PROPOSED DECK 68 WINDING WAY

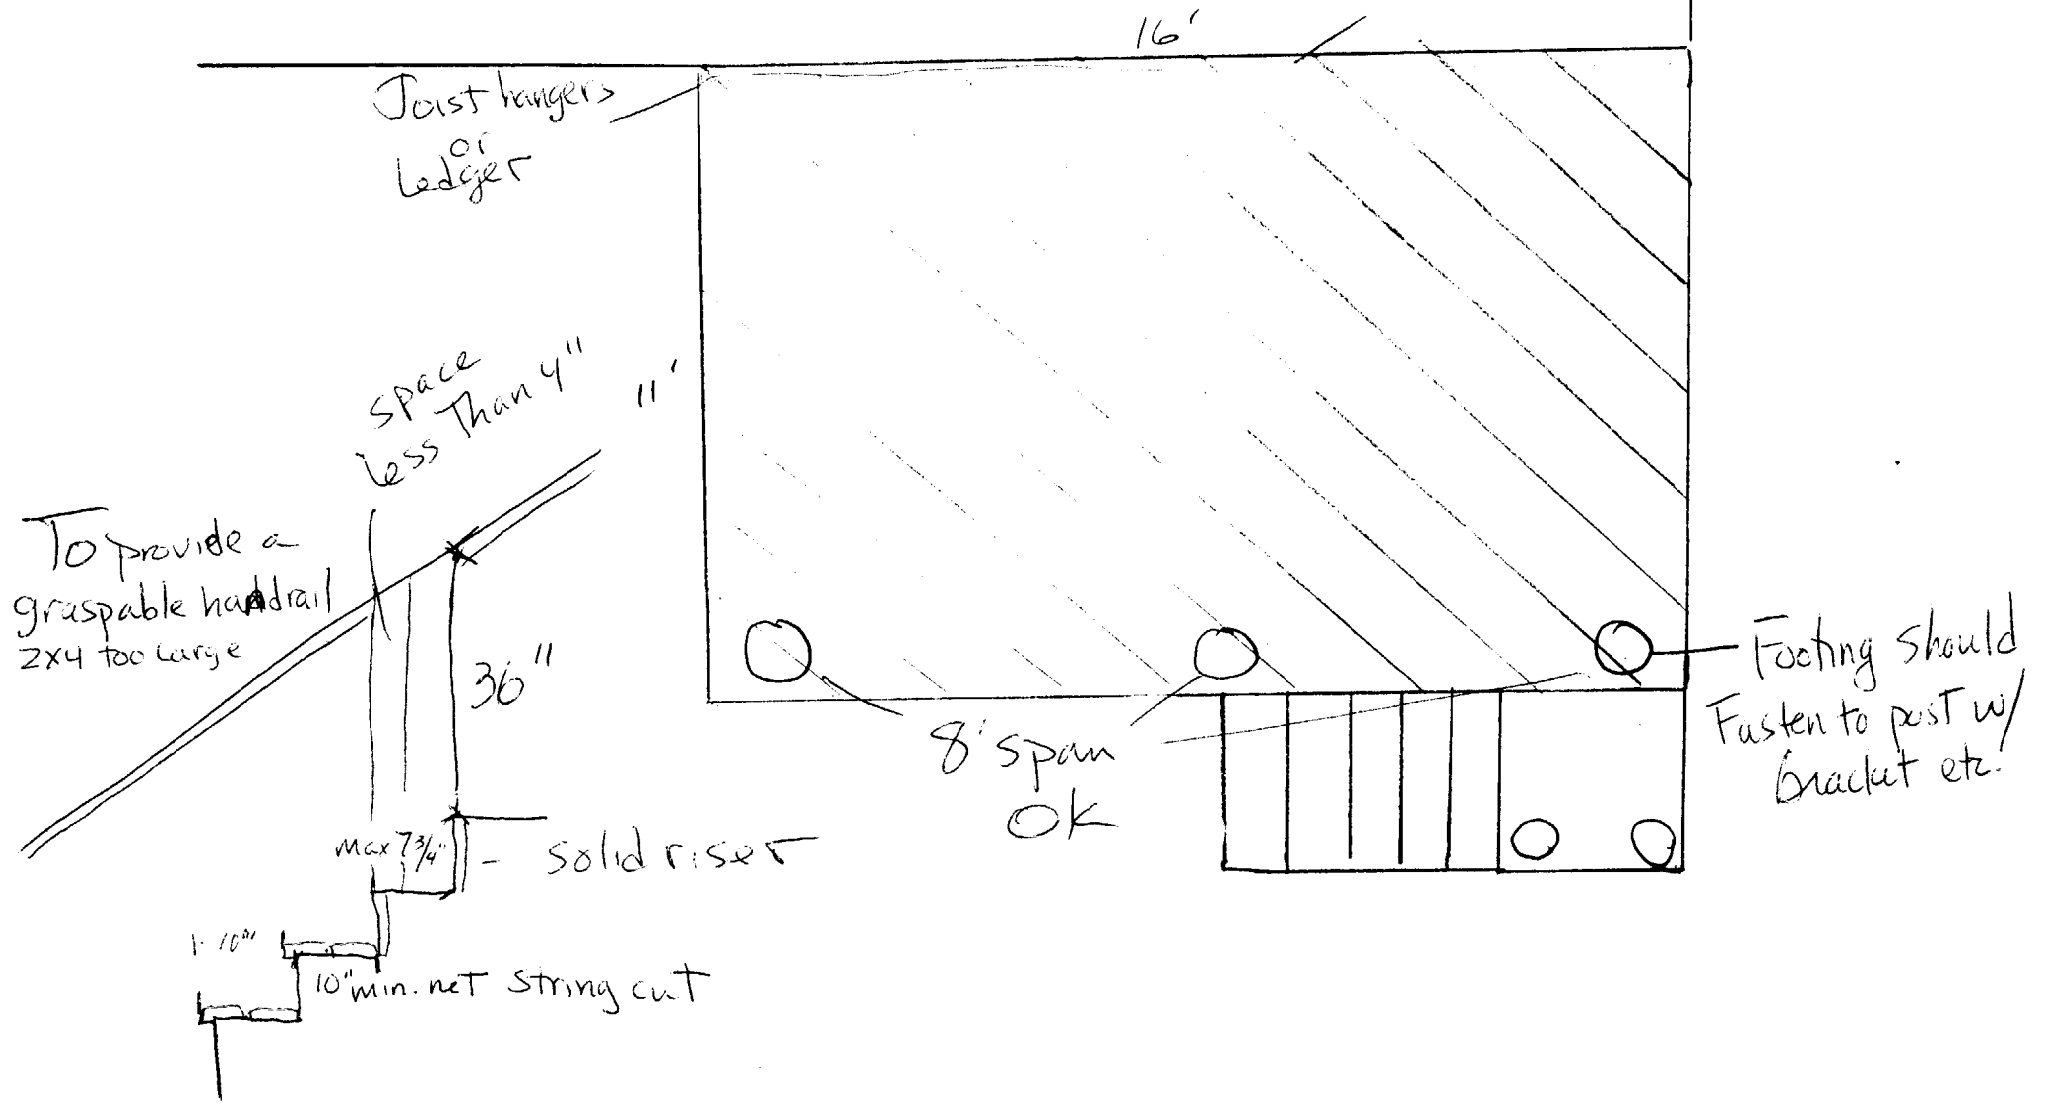
5/12/03 needs go rail/handrail system left
side going ~~the~~ up. She will call when
completed. AR

6/7/03 Handrail system left of Lurline
also for intermediate steps & NO Return
He will want the 34"-36" extensions w/return
Contractor left detailed memo. (P)

6/23/03 completed. A Nowe
